Re: Burger King
5508 4th St. NW
Traffic Circulation Layout
Architect's Stamp 10-27-17 (F14D055)

Based upon the information provided in your submittal received 11-7-17, the above referenced plan cannot be approved for Building Permit until the following comments are addressed:

**H.C. SIGNAGE**  
A0.1 1" = 1'-0"

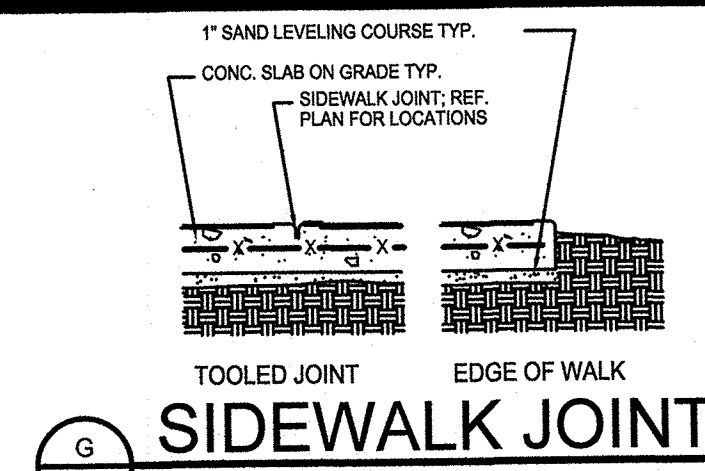
4. The ADA accessible parking sign must have the required language per 66-7-352.4C NMSA 1978 **"Violators Are Subject to a Fine and/or Towing."** Please call out detail and location of HC signs.

**MOTORCYCLE**  
A0.1 1" = 1'-0"

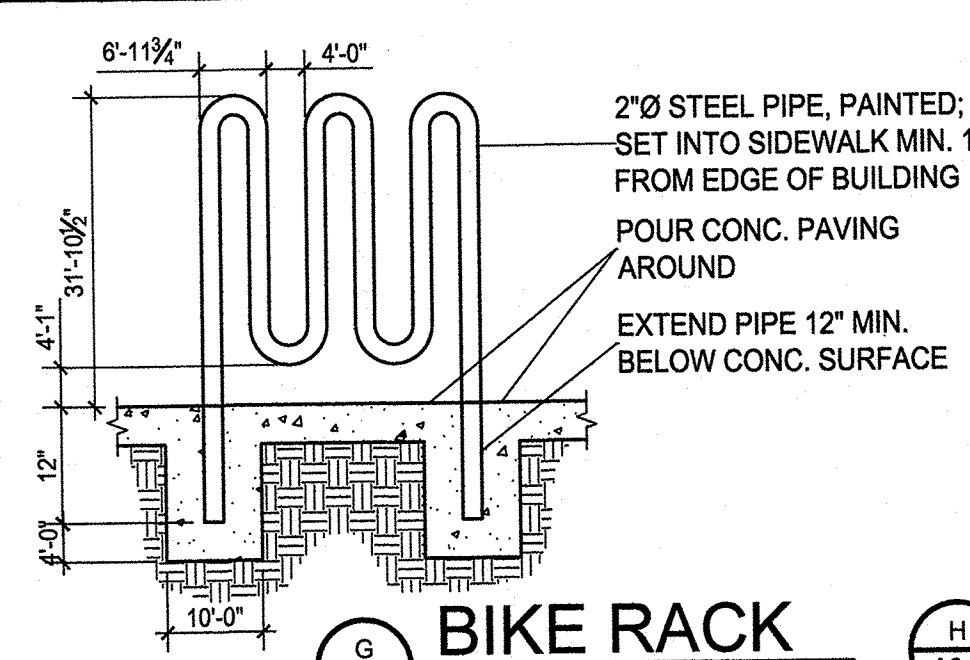
6. Existing sign should be moved within the property Line.
7. Motorcycle parking spaces shall be designated by its own conspicuously posted upright sign, either free-standing or wall mounted per the zoning code.

**DO NOT ENTER SIGN**  
A0.1 3/4" = 1'-0"

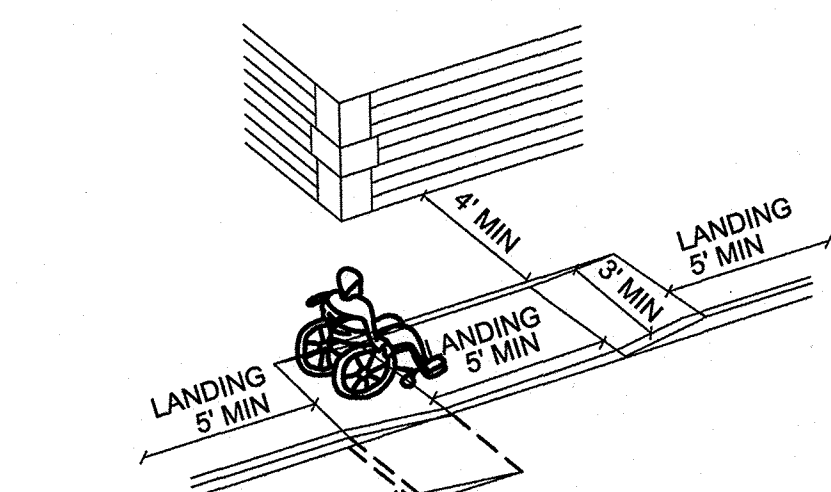
5. One-way vehicular paths require pavement directional signage and a posted **"Do Not Enter"** sign at the point of egress. Please show detail and location of posted signs.

**RAMP STANDARDS**  
A0.1 NTS

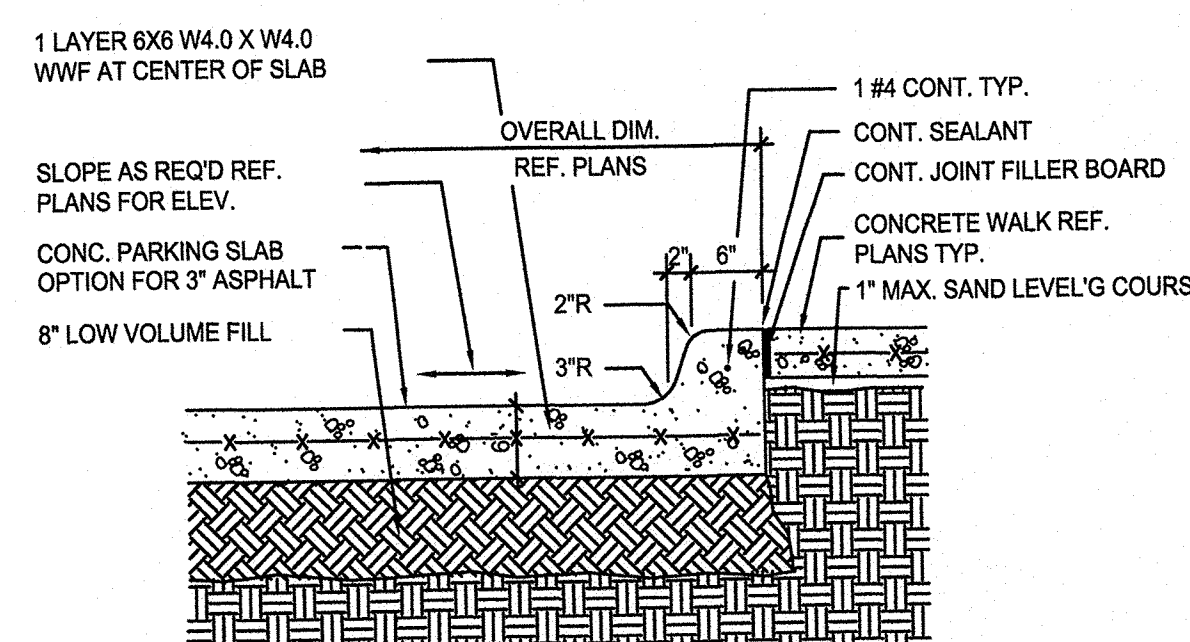
8. Please add to note (7), maximum cross slope is 2% for the ADA Ramp. Correct the slope limit in detail (D). (1:12 is the max slope)
9. Please provide the cross access agreement.

PROJECT # J05-046  
**BURGER KING RESTAURANT**  
5508 4TH ST. NW  
ALBUQUERQUE, NM 87107  
TCL  
A0.1  
TCL

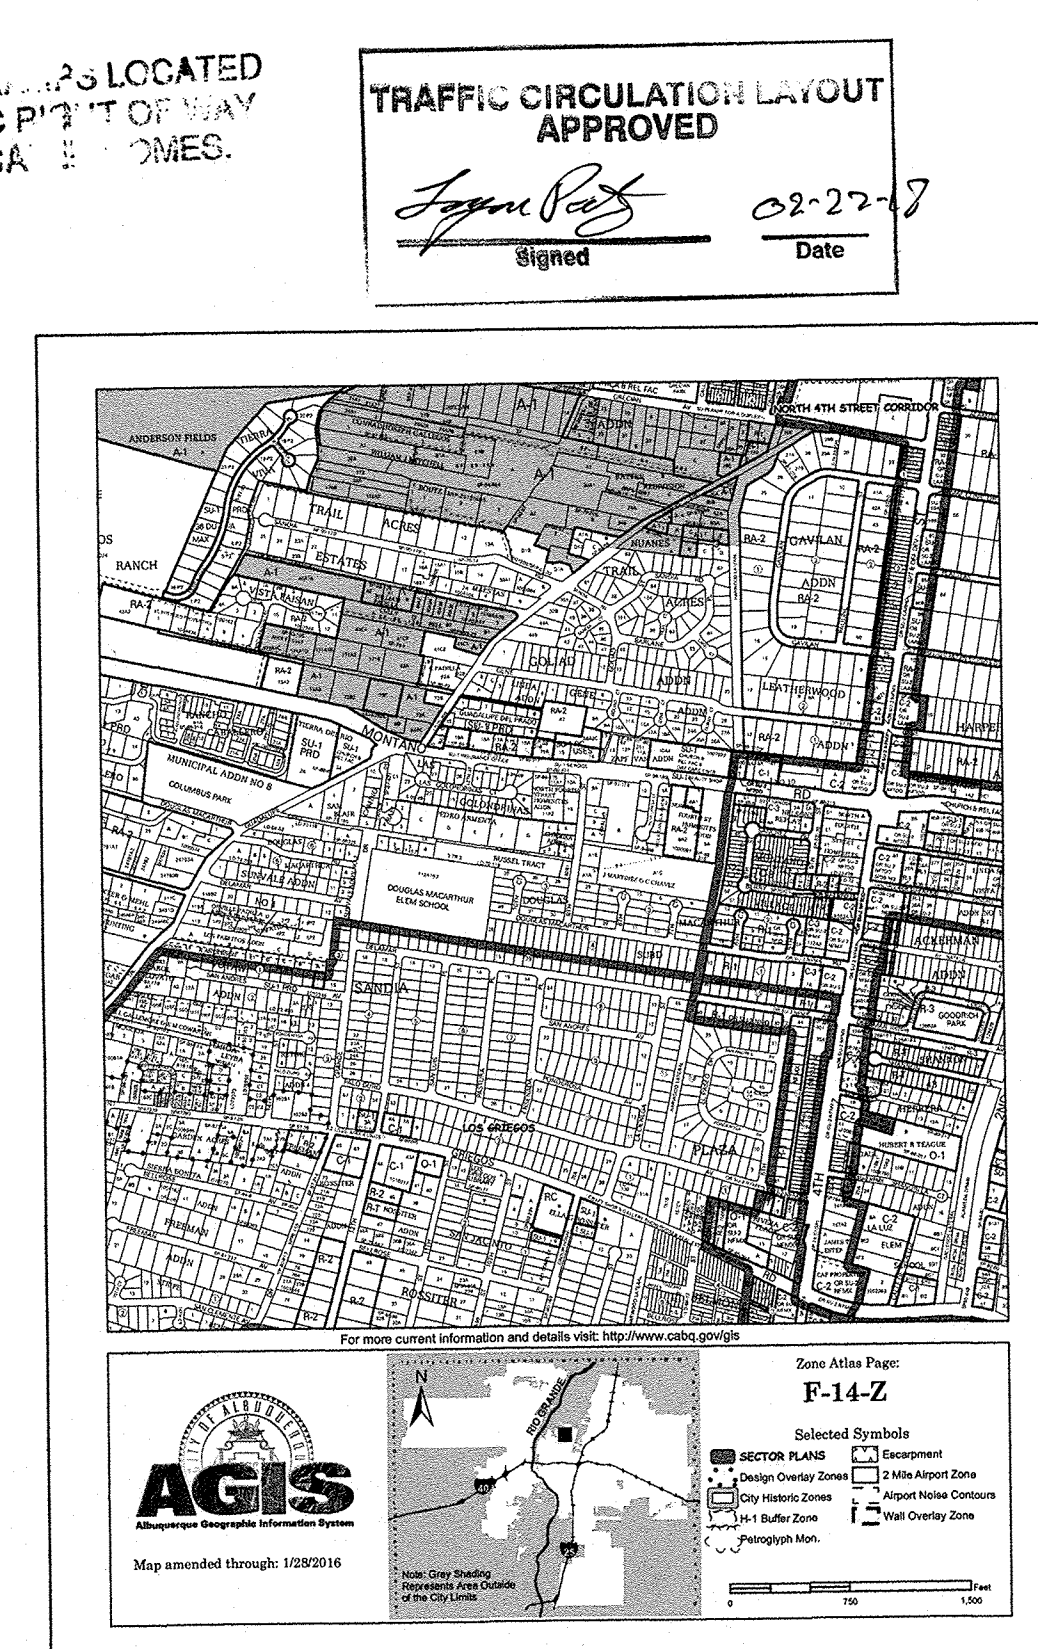
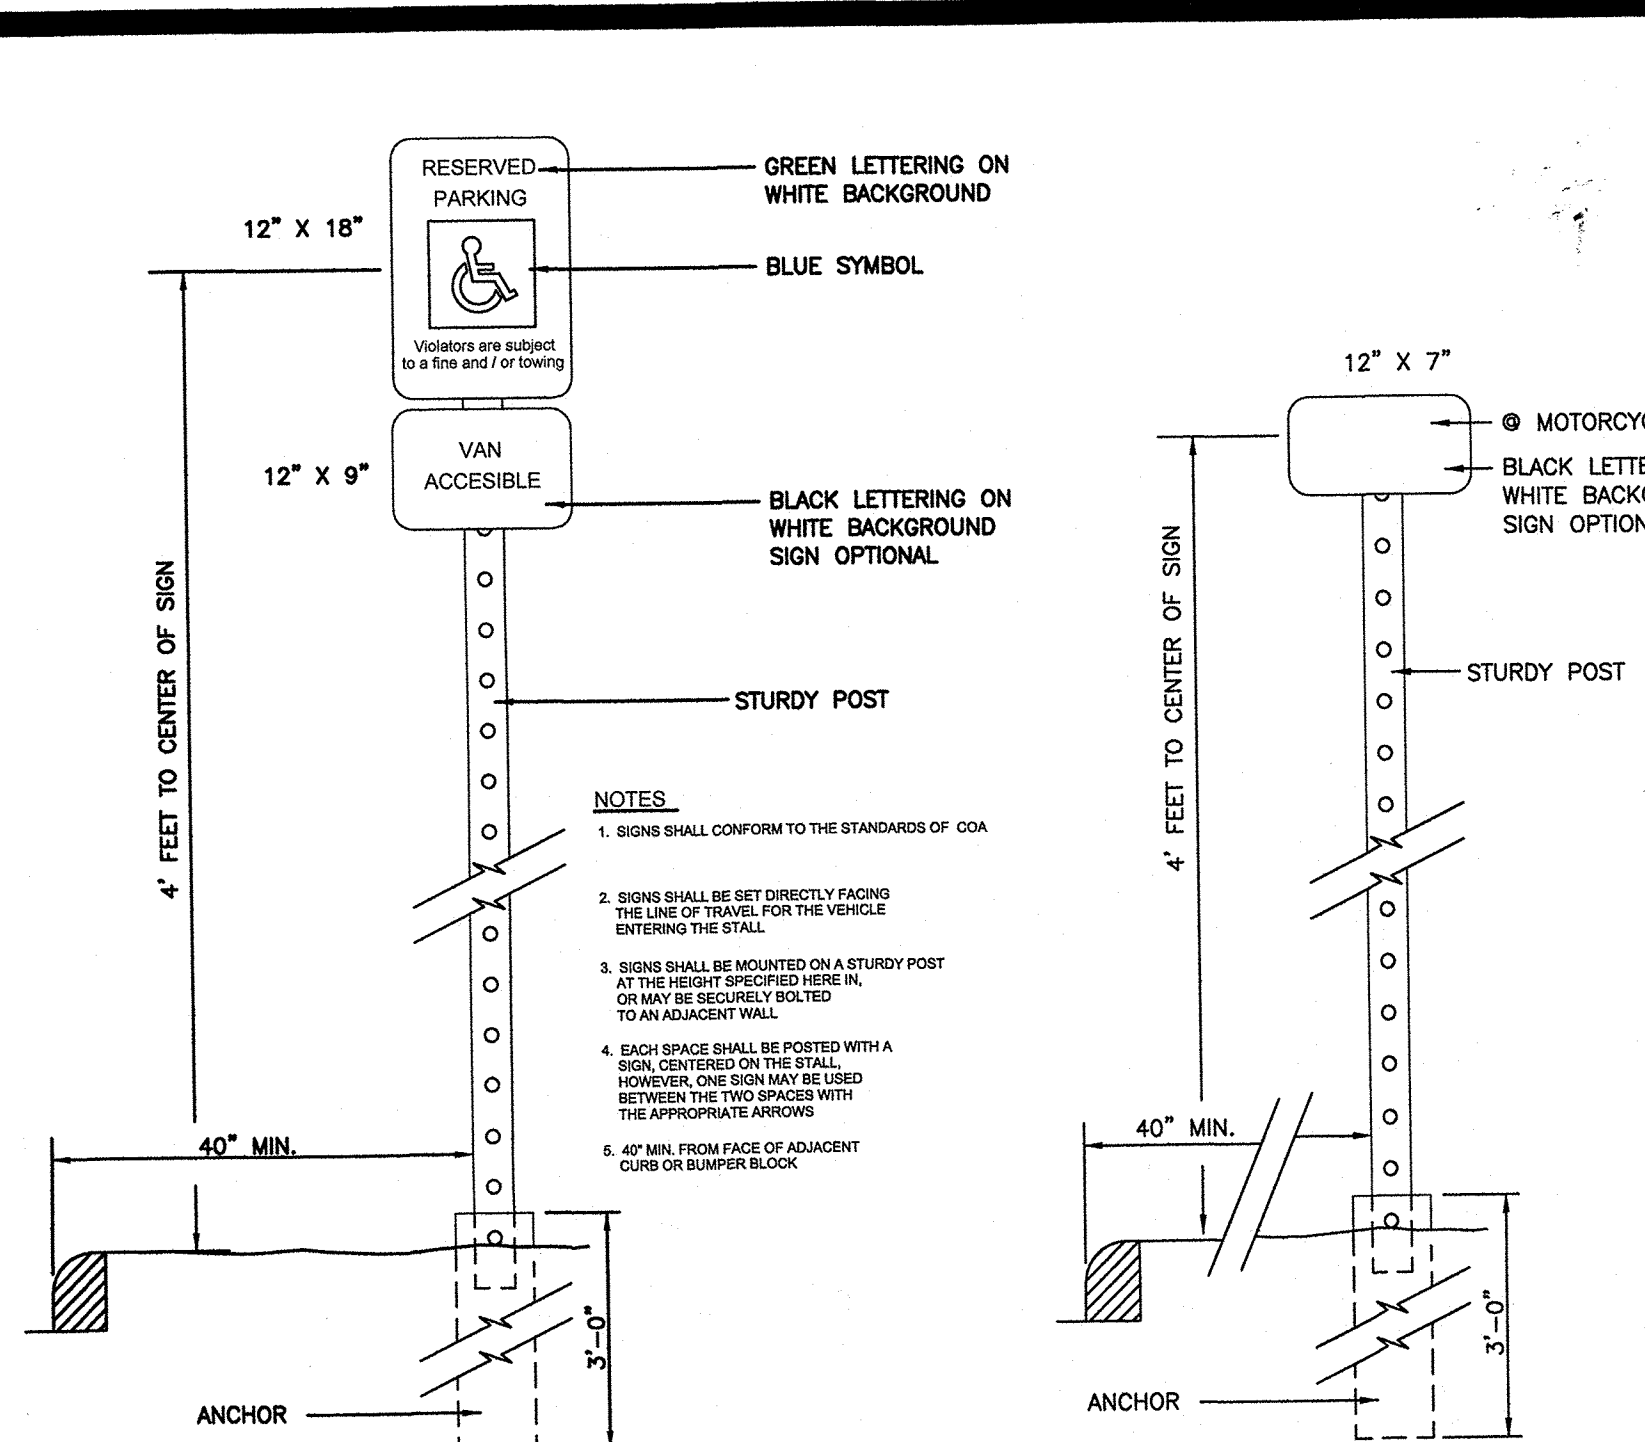
1. The drive through layout is awkward; please look at different site options.
2. Identify the right of way width, sidewalk and street widths on Montano Blvd. 4th St. and Sanchez Rd.

3. Minimum lane widths are 12 feet minimum with a 25-foot minimum radius (inside edge) for all turns. (A 15-foot radius can be used with an increase in lane width to 14 feet).
